Design Integrity Panel | Session 3 | 164-172 and 174-194 William Street, Woolloomooloo

Design Integrity Process: Session 3

Figure 7: Pedestrian wind speed measurement locations with comfort/safety ratings – SSDA Scheme (Configuration C)

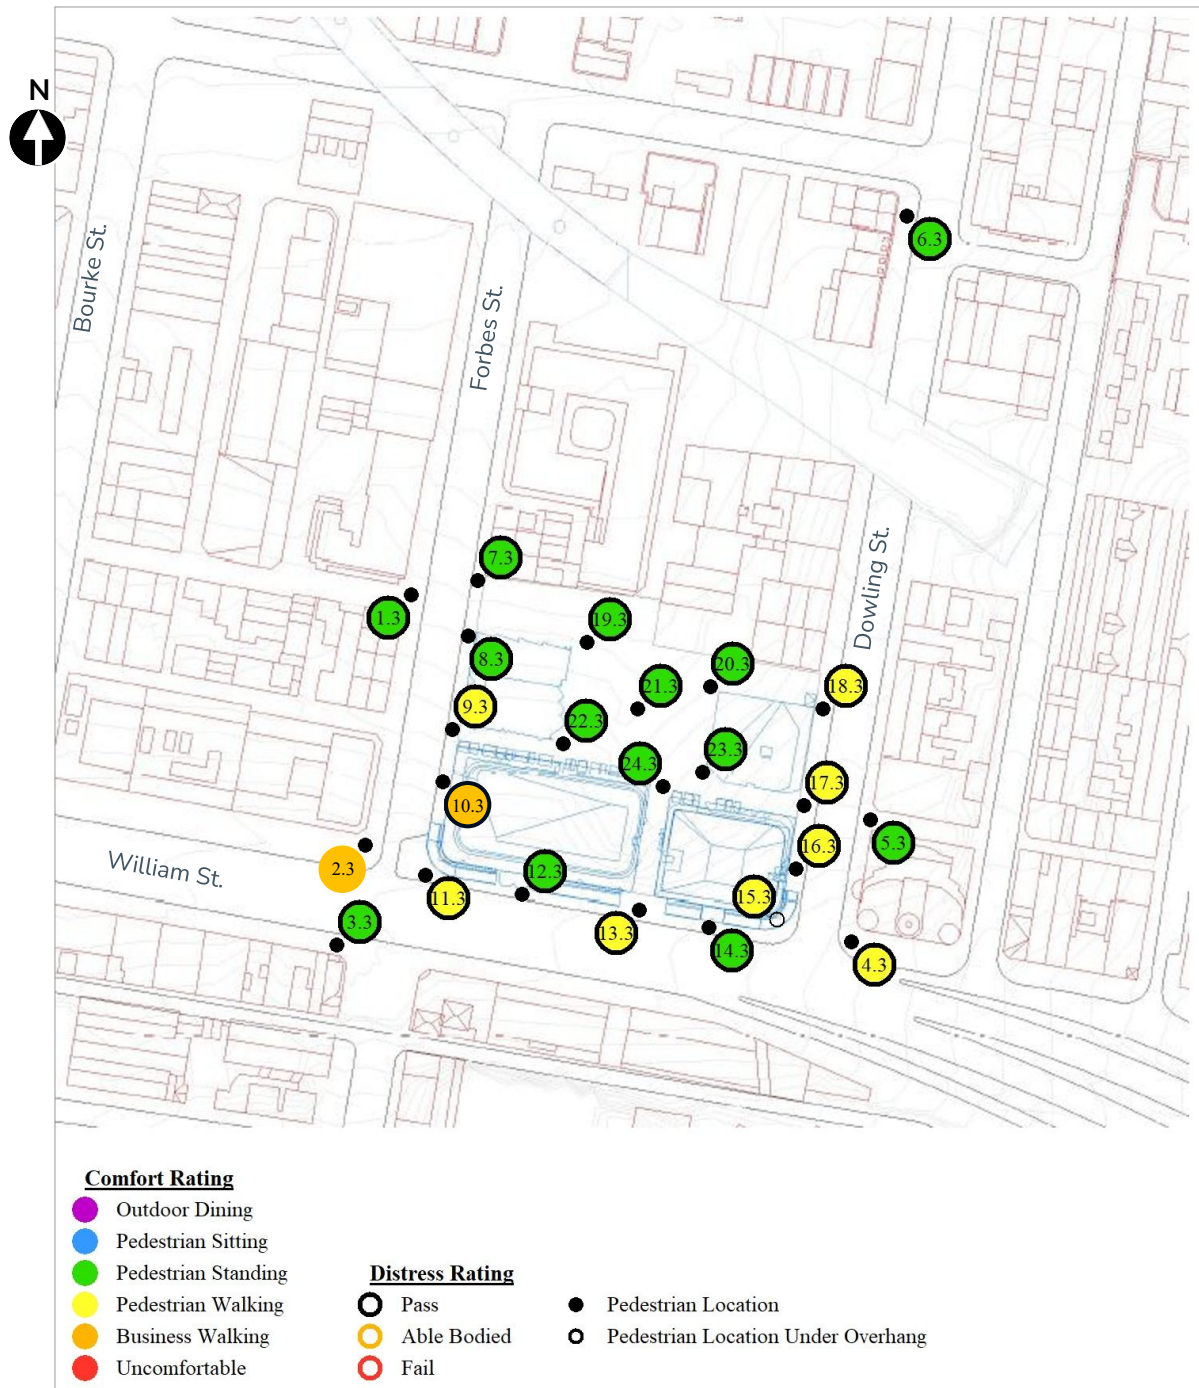
The Panel highlighted that the team should investigate thermal modelling for the façade to reveal the cross-ventilation capability of the William Street West building. The wind report indicates that there are strong westerly winds, particularly at the intersection of William Street and Forbes Street. With refinements to the façade, as discussed separately, there may be further opportunities to increase the cross-ventilation to these apartments.
